**Section 75W Modification (PA08_0212)
New Berrima Clay/Shale Quarry - Environmental Assessment**

NSW Industry, Skills & Regional Development, Division of Resources & Energy (DRE) has reviewed the "Austral Bricks, Environmental Assessment to Support a Section 75W Modification of PA08_0212 for the New Berrima Clay/Shale Quarry, April 2015" and provides the following comments within its area of responsibility.

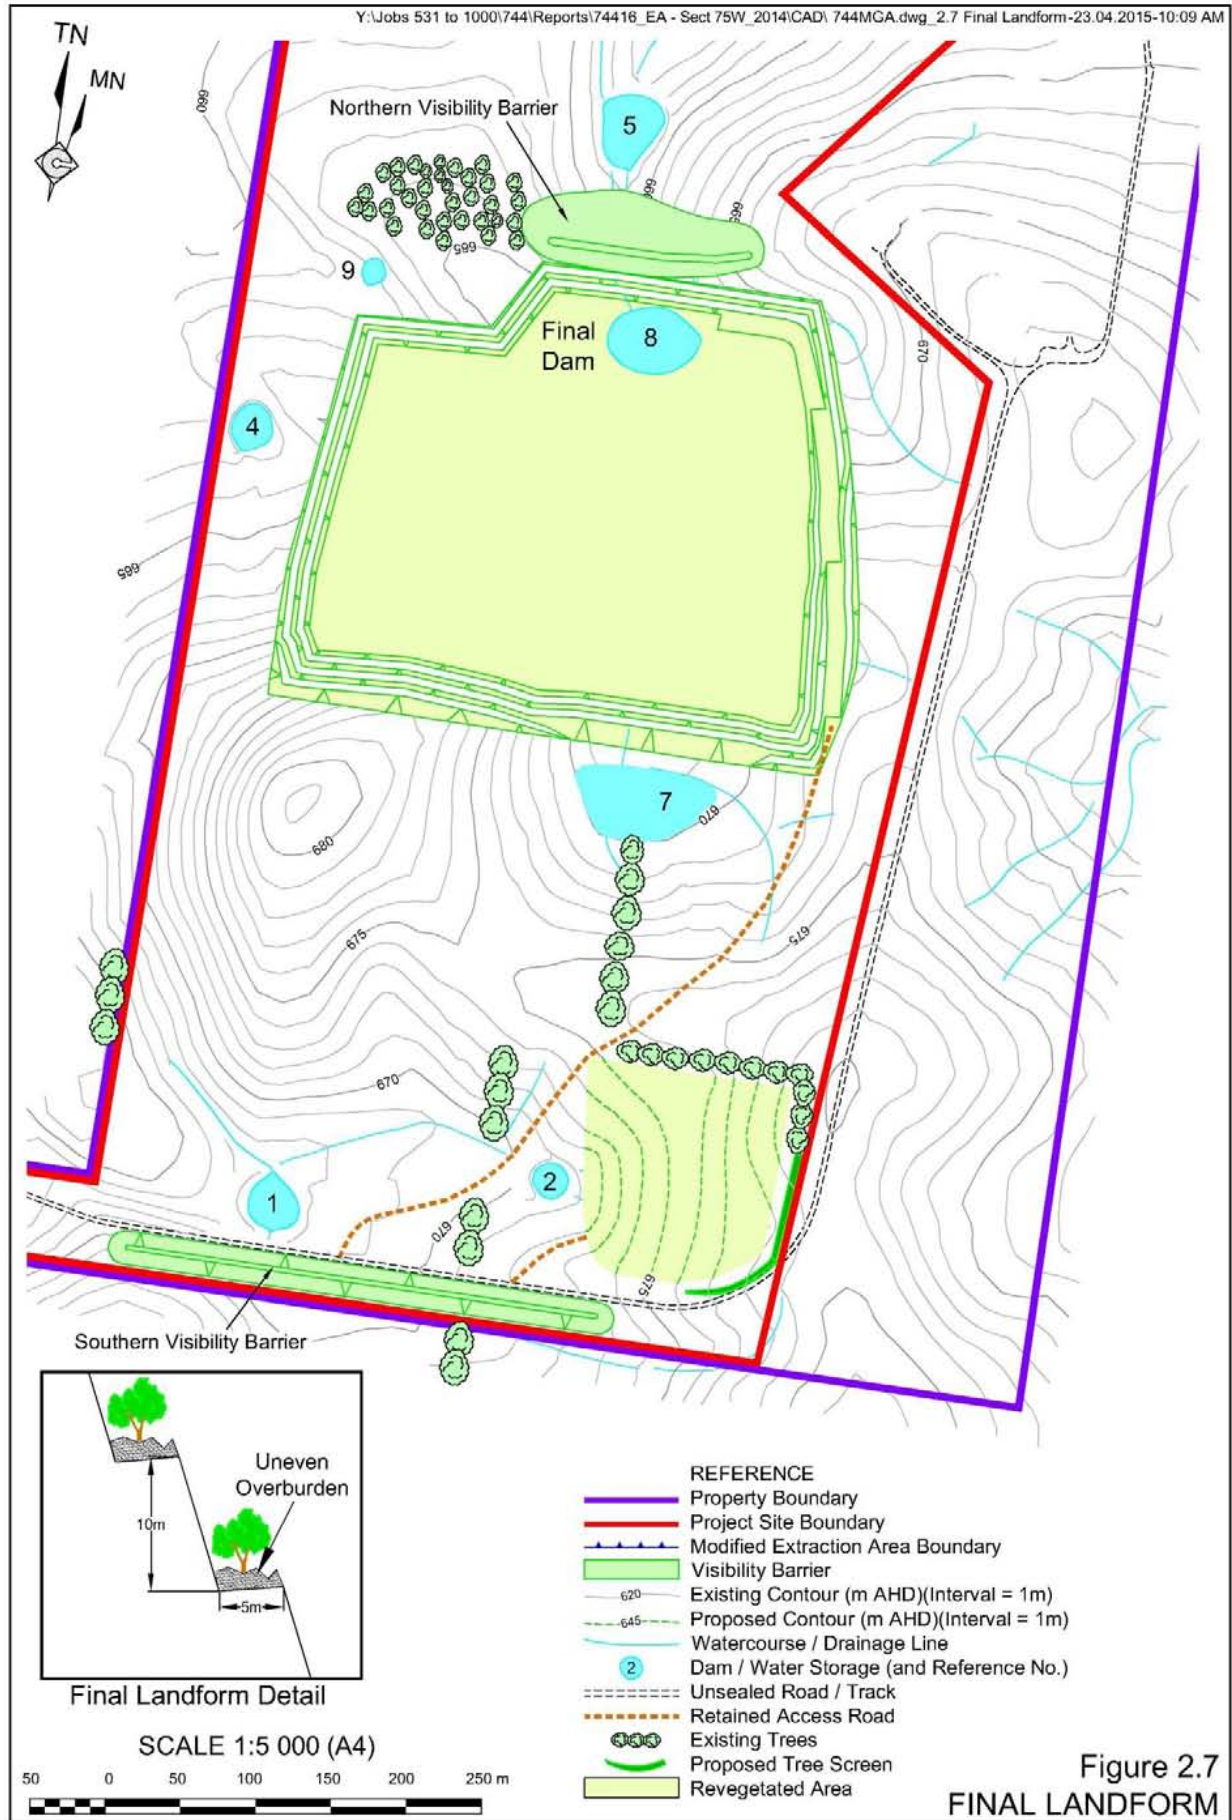
Based on the information provided, DRE does not believe the final landform would be consistent with the surrounding landform, nor safe or stable in the long term.

DRE considers a final landform outcome which incorporates gradual slopes, rather than a steep slope/bench arrangement would be preferable as a rehabilitation outcome in terms of safety (removing a potential fall risk), stability and visual amenity. In addition, DRE would recommend that the required outcome is for the sides of the extraction area to have slopes of no greater than 18 degrees (1V:3H).

There appears to be no documentation in either this Environmental Assessment or the original December 2010 Environmental Assessment covering consideration of alternative rehabilitation landforms or outcomes.

As a result, Austral Brick Company Pty Limited Bricks should be required prepare a more detailed consideration of alternative rehabilitation/landform options, including the positive and negative aspects of each and a subsequent justification for the chosen outcome.
